**Re: Objection to MP08\_0244 MOD 1 Modification Request for Mixed Used Development at 23-37 Lindfield Avenue and 11 Havilah Lane, Lindfield**

3 SHADOW DIAGRAM - 21stDEC_3PM
5003 SCALE1 : 650

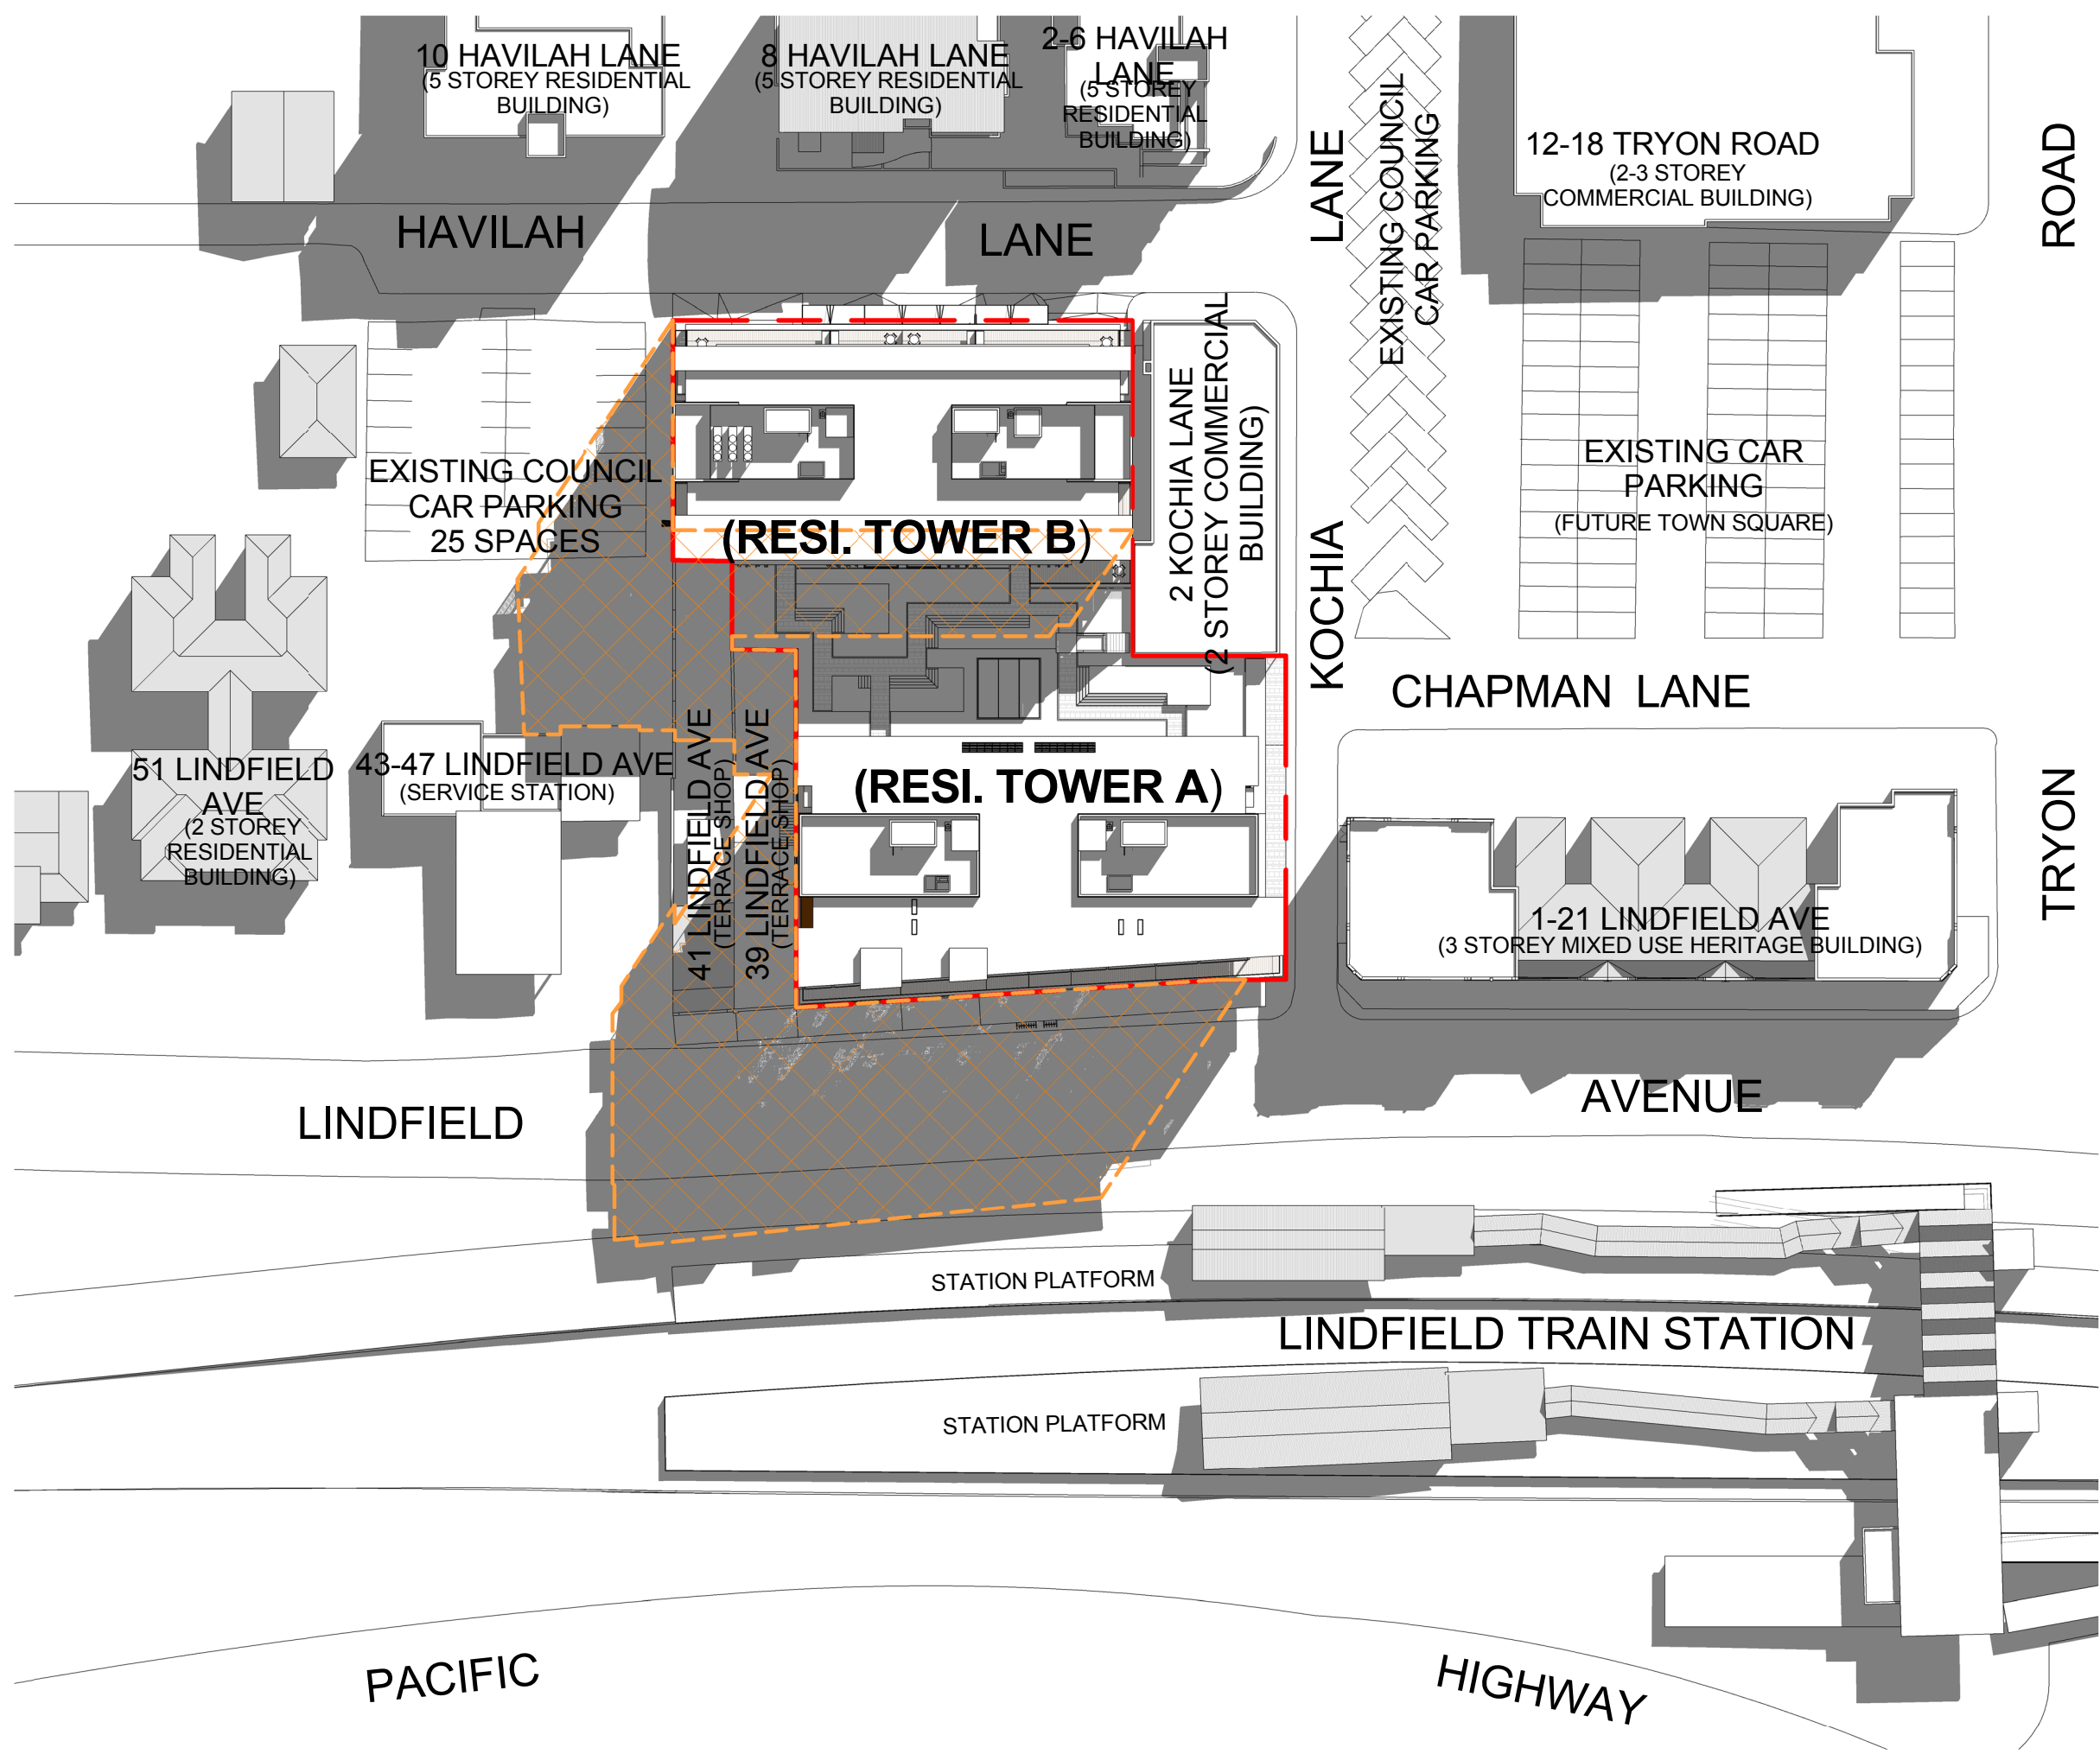
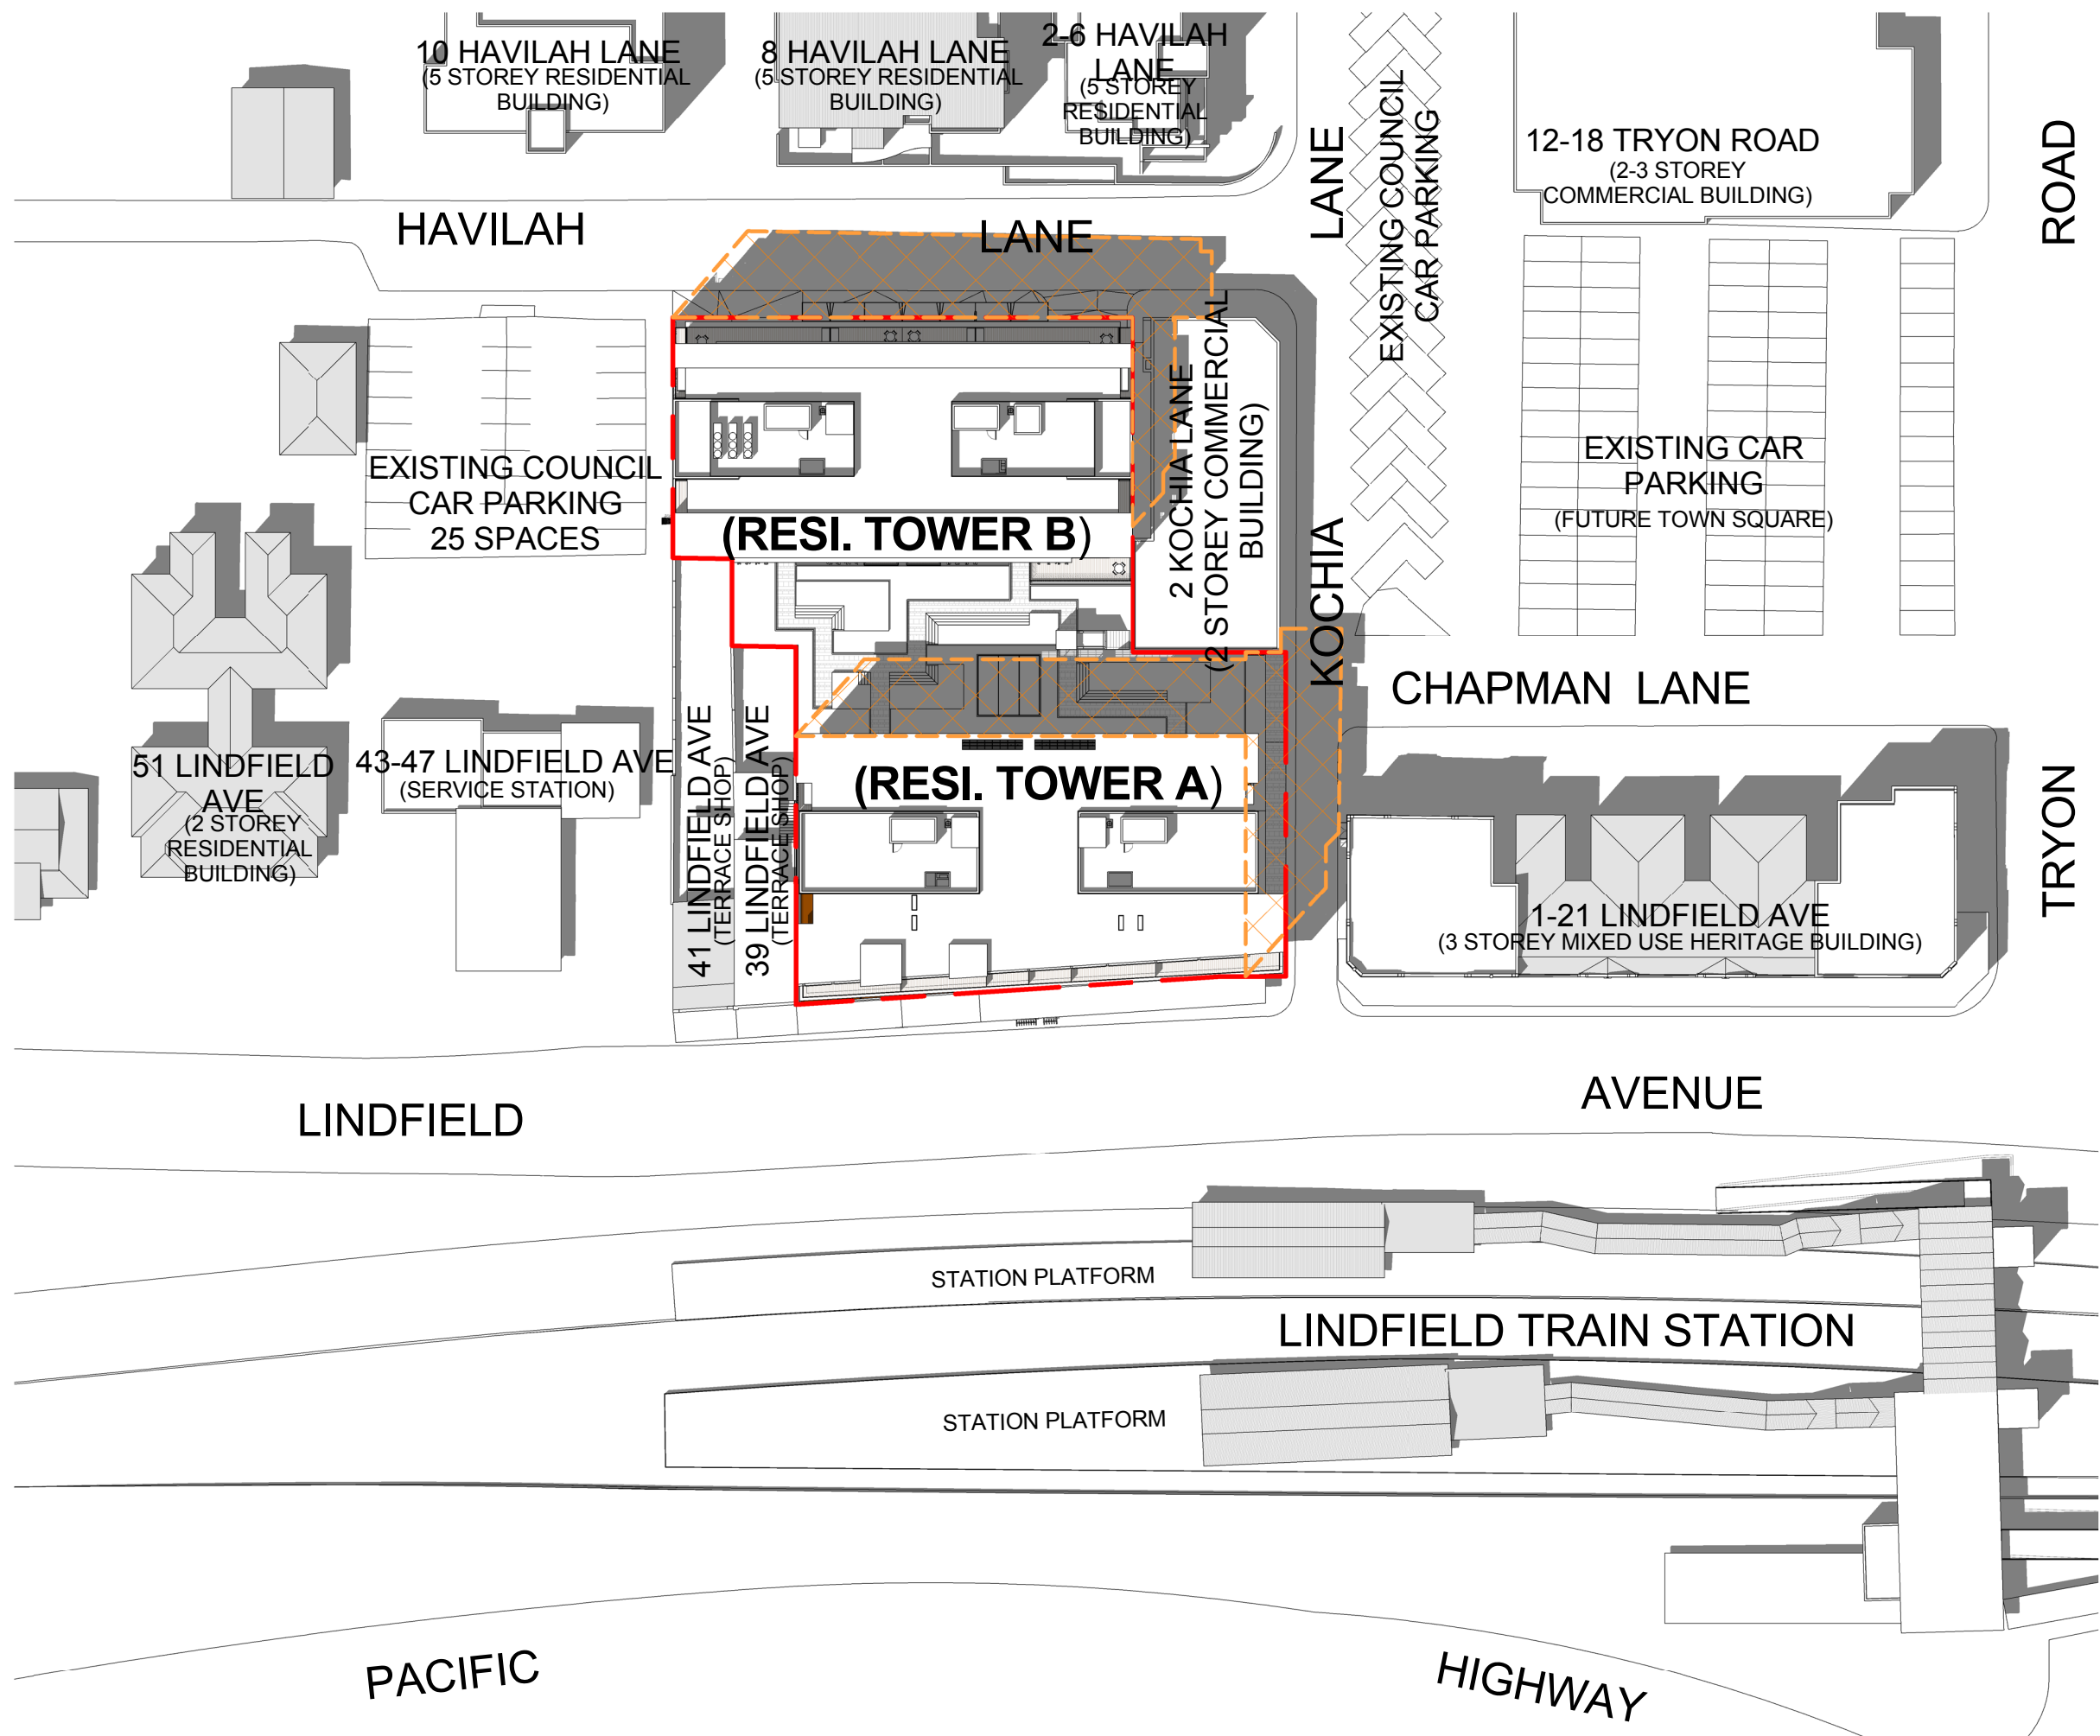
- The additional storeys create additional shadowing: particularly after 3pm for residents in the Havilah Lane apartments, and for all commuters on the city bound Lindfield rail platform, instead of 50% of the year, it will now be 75% of the year in the mornings.
